PROJECT TITLE
MALLARD PASS SOLAR FARM

DRAWING TITLE
Figure 4.3: Concept Masterplan

Viewpoints

DRAWING TITLE
Figure 6.6: Zone of Theoretical Visibility (ZTV) Study, Representative Viewpoints and Illustrative Viewpoints

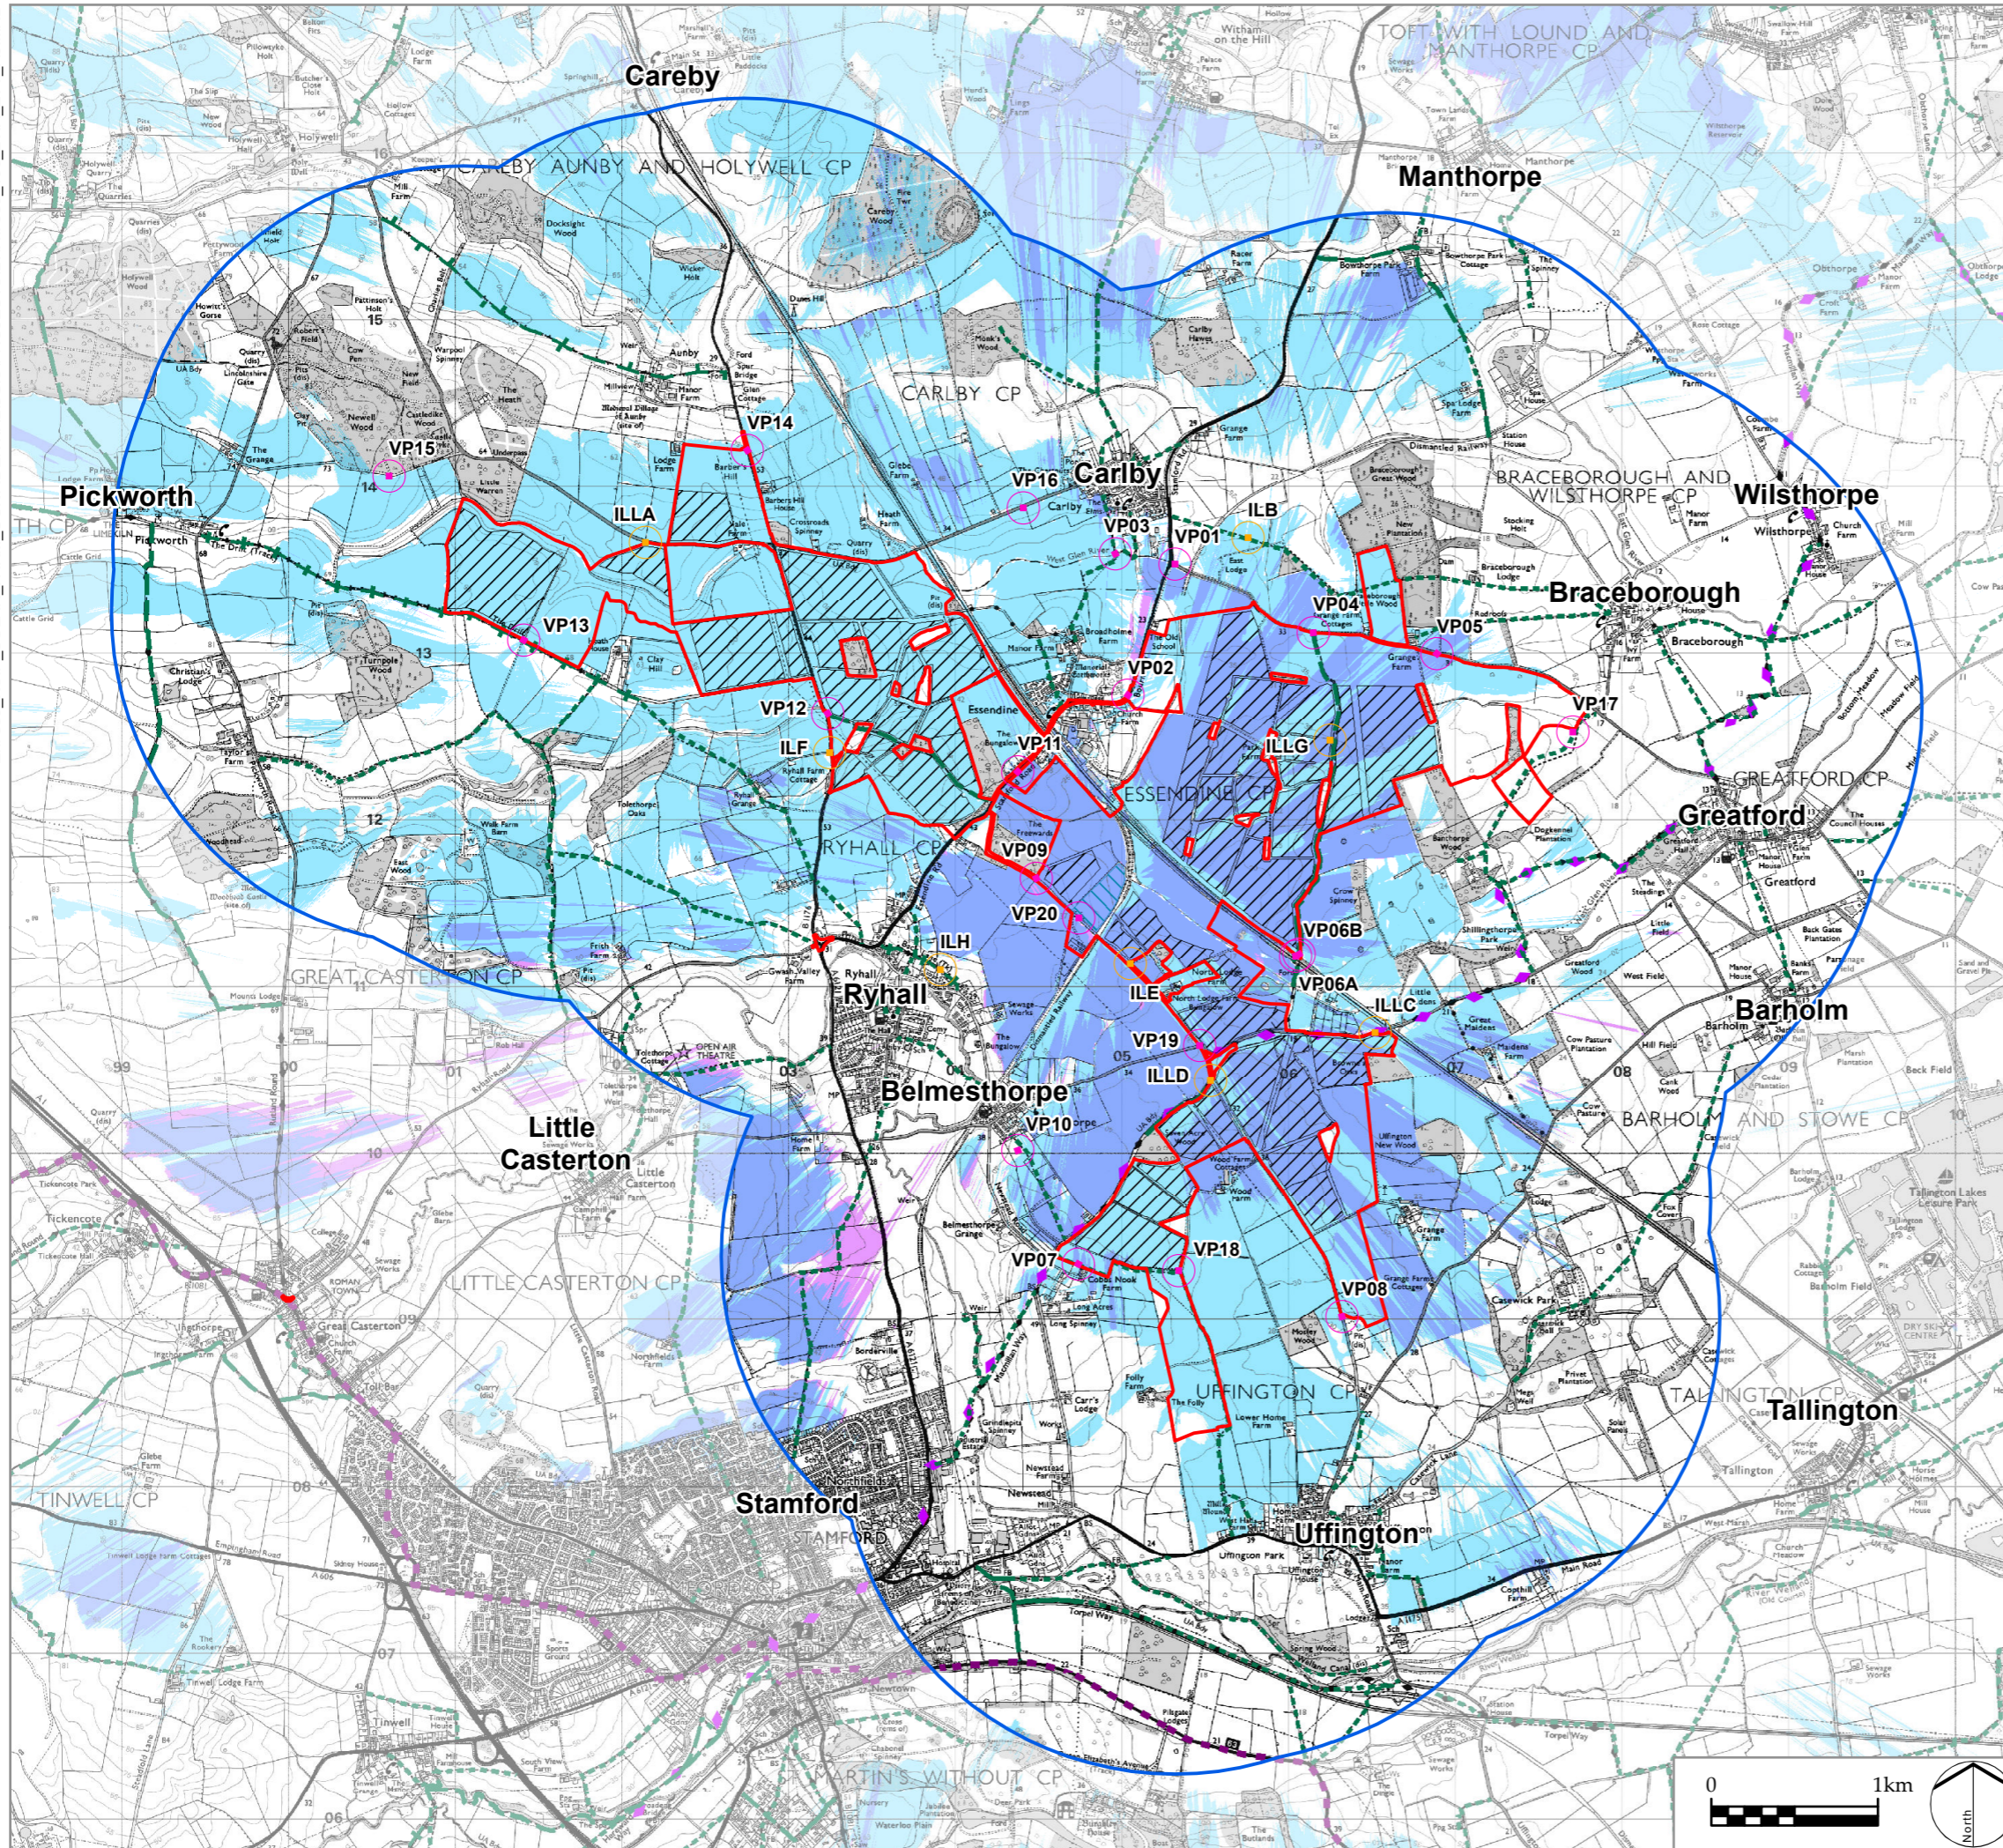
File name	Grid ref for location search	Description of location	Comments	Date of MPSF photo
Viewpoint 1	52.709252 , -0.44255922	Carlby Rd near Junction A6121 Bourne Road	MPSF have now moved the solar boundary back in field 27 and 29 behind the gas pipeline. Some solar will be visible in the distance but far less. The triangle piece of land on the corner of A6121 & Carlby Rd is not part of the site, so when you travel East along Carlby road the solar will be quite visible to the south.	27.01.22
Viewpoint 1 MPAG	52.7078188, -0.4375330	Carlby Raod adjacent to the gas pipeline, to the east of it in field 29 & 27 will be solar, to the west no solar as a residential setback to Essendine village	When you travel East along Carlby Raod along the edge of the triangle there is and will be little screening until you reach field 33 as it is not part of the site.	Suggested
Viewpoint 2	52.702234 , -0.44698271	A6121 Bourne road, east of essendine village, on bend	Unlikely to see solar, looks onto field 27 but there is now residential setback distance behind the pipeline	27.01.22

Viewpoint 3	52.709878 , -0.44783631	Public footpath Carlby located nr West Glen River between Essendine & carlby	Strange choice of VP, only recreational & well away from any solar on edge of Carlby village down a hill by the river on PRoW E171. Topography provides screening.	27.01.22
Viewpoint 4	52.705387 , -0.43042652	Carlby Road near layby and junction with Bridleway BrAW/1/1	Key viewpoint across field 36, and also across to 29,30 and 34; the largest solar area on the site with wide open vistas; a key bridleway 1.5 miles long with even more expansive views further down the path.	27.01.22
Viewpoint 5	52.704100 , -0.41944606	Carlby Road to east of Braceborough Grange	Slightly wrong position, it should be directly next to the PRoW BrAW/3/1. Walkers then walk up Carlby Rd to BrAW/1/1 to do a circular walk. Whilst the solar will start c200m offset from the road, it is such a big field field 36, new screening at 200m out will never mitigate the impact. The road sits higher than the arable land making the view even more accessible.	27.01.22

Viewpoint 6a	52.688051 , -0.43227626	Bridleway BrAW/1/1 on railway bridge near North Lodge Farm (view east of railway)	This is at the other end of BrAW/1/1 next to field 35 which is huge BUT where they have taken it next to the railway bridge is at the lowest point possible. Move a few yards North and you can see all the way across to field 35,32,31,27 and 29.	27.01.22
Viewpoint 6b	52.687957 , -0.43260515	Bridleway BrAW/1/1 on railway bridge near North Lodge Farm (view west of railway)	This is taken at the same position as 6a but looking over the railway bridge. If it was on the south side of the bridge logically, fields 21, 24 & 25 may be visible	27.01.22
Viewpoint 7	52.671594 , -0.45244719	Public footpath Uffi/5/1 to east of Newstead Lane and Cobbs Nook Farm	This is currently an open vista on PRoW Uffi/5/1 across fields 45, 46 & 47, which branches off the famous McMillan Way PRoW.	27.01.22

Viewpoint 8	52.668456 , -0.42917696	Essendine Road to north of Wood Farm Cottage and east of Morley Wood	There is no solar in adjacent field 52.	27.01.22
Viewpoint 8 MPAG	52.6696474 , -0.4297060		Limited views to fields 45 & 46	Suggested

File name	Grid ref for location search	Description of location	Comments	Date of MPSF
Viewpoint 10	52.677802 , -0.45762685	Public footpath E174 to the south of Belmesthorpe village	This VP is on the edge of Belmesthorpe village at the start of ProW E174. The closest solar fields are 45,46 & 47, but they are shielded by topography and the wooded corridor of the ProW famous McMillan Way. It is highly likely that walkers could end up on UFFI/5/1 at VP7 with 3 fields of solar though.	27.01.22
Viewpoint 11	52.698228 , -0.45690694	A6121 Stamford Road on the south-west approach to Essendine (betw hs2 & 3)	This VP is on the main A6121 from the market towns of Stamford and Bourne. The solar area in field 18 and new sub-station to 13m high in field 19 will be visible (and audible) from the main road due to the topography affecting some residents, walkers & passing traffic. We stood at this point with SKDC Planning Officer when they were spraying field 18 and it is clear screening will never work.	27.01.22

Viewpoint 11 MPAG(1)	52.7037784 , -0.4588942	Down Pickworth road off A6121	Key area for walkers, field 11 solar quite visible	Suggested
Viewpoint 11 MPAG(2)	52.7065954 , -0.4659664	Further north down Pickworth road off A6121	Looks across to 5,7,8, possibly more solar fields	Suggested
Viewpoint 12	52.701601 , -0.47367475	Field access at junction of Bridleway E169 with B1176 to north of Ryhall village	Solar will be visible to passing traffic at the VP and especially visible to walkers/riders using ProW adjacent to fields 9, 13 & 14	27.01.22
Viewpoint 13	52.705881 , -0.50052311	The Drift (track) and Byway Open To All Traffic (BOAT) E123 between Ryall Heath Farm and Pickworth	Starts at double gates in Field 3 with solar on left and mitigation on right, evident to all users of the byway, recreational. Another VP closer to Pickworth would look even worse	27.01.22
Viewpoint 13 MPAG	52.7037149 , -0.4748844	At entrance to The Drift byway	Field 2 solar clearly visible to both B1176 and the Drift users	Suggested

Viewpoint 14	52.715882 , -0.48032701	B1176 Road at Barber's Hill (parallel to Clematis Cottages)	This VP has been taken over the north side of the brow of the hill at an access point to a compound, so the solar in field 4 will not be easy visible from the road. A strange choice of VP, see revised VP.	28.01.22
Viewpoint 14 MPAG(1)	52.7139037 , -0.4788927	Opposite Barbers Hill House on the brow of the hill	Positioning on the brow of the hill heading South drivers will clearly see field 2 of solar and some of 4 thru hedge, especially riders/cyclist	Suggested
Viewpoint 14 MPAG(2)	52.7108163 , -0.4779939	Carlby crossroad on B1176	Full view east of B1176 across solar fields 5,6,7,8 and west 4	Suggested
Viewpoint 15	52.714901 , -0.51217578	Rural lane to the south of Newell Wood (1st bend in rd)	Field 3 of solar will be visible in the distance from the edge of this wood over the stone wall. Can't be screened as it is of the site.	24.06.22

Viewpoint 15 MPAG	52.7132141 , -0.4958161	On the other side of Newell road on Holywell Rd	Looking directly across to field 3 of solar along Pickworth road next to SSSIs, due to undulation	Suggested
Viewpoint 16	52.712465 , -0.45591612	Rural lane between the railway underpass and Carlby village	Just 100m or so outside Carlby village and can see across to 5 mainly, due to topography.	24.06.22
Viewpoint 16 MPAG	52.7114577 , -0.4605765	Rural lane between the railway underpass and Carlby village	Another 50m or from above due to topography can see across to 5,7,8,10	Suggested
Viewpoint 16 MPAG	52.7102817 , -0.4753260	Rural lane heading to B1176 crossroads	Can see south across solar field 5, 6, 8 etc	Suggested

File name	Grid ref for location search	Description of location	Comments	Date of MPSF photo
Viewpoint 17	52.699724 , -0.40755740	Public Footpath BrAW/7/1 between Carlby Road and Banthorpe Wood	Away from the site and the solar area and the topography is downhill from field 36 where the first solar is. However it affects recreational amenity as part of a circular routes with BrAW/1/1	24.06.22
Viewpoint 18	52.671127 , -0.44356030	Public Footpath Uffi/5/1 on the farm track between Cobbs Nook Farm and Uffington	Close to VP7 and on same footpath. Field 45 more visible than 46 & 47.	24.06.22
Viewpoint 19	52.683252 , -0.44126524	Junction of rural lane (Main Street) and Essendine Road near the marker post	At a T junction heading to Belmesthorpe, Uffington, Essendine and Greatford. Big gaps in hedge due to car crashes making field 25 quite visible currently. Gaps will no doubt be filled.	24.06.22
Viewpoint 20	52.690267 , -0.45175743	Essendine Road near access to the existing Ryhall electricity sub-station	The new sub-station will be in field 19 opposite the existing Nat Grid sub station, so from this VP on quietish back lane, it will not be as big an issue as from VP 11.	24.06.22

File name	Grid ref for location search	Description of location	Comments	Date of MPSF photo
Illustrative Viewpoint A	52.711028 , -0.48955518	Holywell Lane between Little Warren, Vale Farm and Crossroads Spinney	Strange choice, although to SSSI no di	24.06.22
Illustrative Viewpoint A MPAG(1)	52.7108000 , -0.4873289	Slightly further west on Holywell road from IVP A	Just west few yards from above can see field 1 of solar through gateways, and through the hedge field 4 of solar	Suggested
Illustrative Viewpoint A MPAG(2)	52.7108429 , -0.4845042	Holywell rd nearer crossroads	View of solar field 4 through gateway	Suggested
Illustrative Viewpoint B	52.710586 , -0.43601316	Public Footpath Carl/4/1 between Carlby and Braceborough Great Wood	The topography is downhill from the solar area in field 36 so no impact, strange choice of illustrative VP	24.06.22
Illustrative Viewpoint C	52.683747 , -0.42568433	Macmillan Way following highway near railway crossing at Banthorpe Lodge	Fields 53 & 49 adjacent to road and McMillan Way - not sure about hedgerow?	24.06.22

Illustrative Viewpoint D	52.681361 , -0.44038579	Macmillan Way PRoW (Bridleway E183) at junction of Essendine Road	An important ProW. There is some hedge gapping in finto fields 48 & 49	24.06.22
Illustrative Viewpoint E	52.687754 , -0.44727457	Essendine Road near North Lodge Farm	Close to sub-station. Can see through gate to filed 22 otherwise good hedging	24.06.22
Illustrative Viewpoint F	52.699487 , -0.47358570	B1176 on access to Keepers Cottage, Ryhall Farm Cottage and Ryhall Grange	Can see North on B1176 towards field 9, odd choice	24.06.22
Illustrative Viewpoint G	52.699572 , -0.42914043	Public footpath BrAW/1/1 Banthorpe Lodge, the railway bridge and the Carlby Road	On main bridleway can see either side into all of field 36 and the other side to field 34,30 and 31.	30.07.22
Illustrative Viewpoint H	52.687641 , -0.46415996	Back Lane (track and byway) at Ryhall	Pointless location as doesn't connect to any solar areas	24.06.22

Photomontage A - VP1	52.709252 , -0.44255922	Same location as Viewpoint 1	Locations picked and photographed before they put the solar setbacks in, so photomontages wrong.	27.01.22
Photomontage B - VP2	52.702234 , -0.44698271	Same location as Viewpoint 2	Locations picked and photographed before they put the solar setbacks in, so photomontages wrong.	27.01.22
Photomontage C - VP4	52.705387 , -0.43042652	Same location as Viewpoint 4	Most open vista across the site, albeit VP G is more representative of the recreational experience.	27.01.22
Photomontage D - VP8	52.668456 , -0.42917696	Same location as Viewpoint 8	No logic for this choice!	27.01.22
Photomontage E - VP11	52.698228 , -0.45690694	Same location as Viewpoint 11	Very relevant but PM is poor representation of what will be seen. How do you screen 13m of sub station?	27.01.22
Huge impact				
Reasonable impact				
Little impact				
MPAG suggested VPs
